Town & Country Planning (Control of Advertisement) (England) Regulations 2007 (as amended)

Application for Consent to Display an Advertisement(s)

Development: Installation of various signage.
Location: The Co-Operative Food 1 Steeplechase Way Fontwell BN18 8UF

Car Park Signage

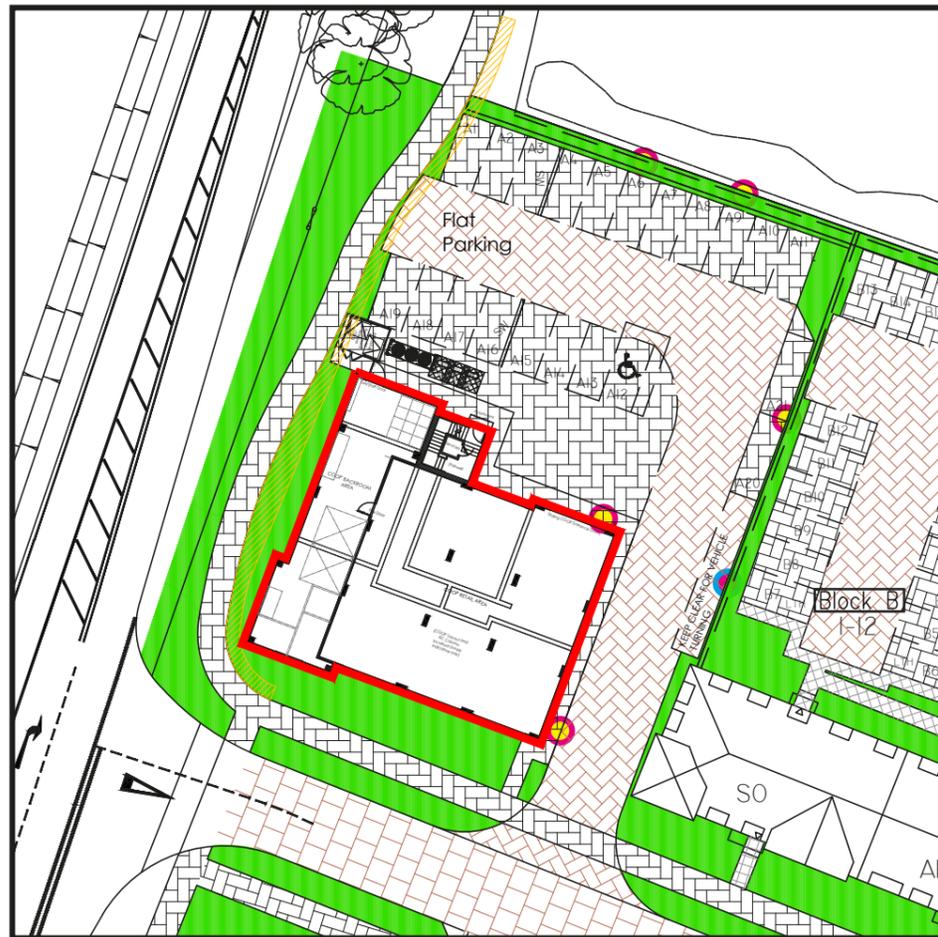
Car Park Signage

Please add dimensions to the proposed car park signs.

Signage Specification

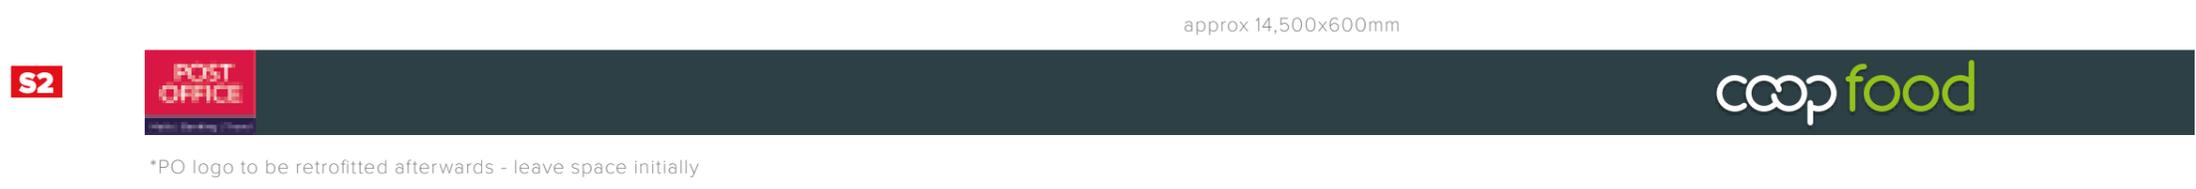
Wall Signage

The wall signage plans are not measuring to scale, please review and amend.
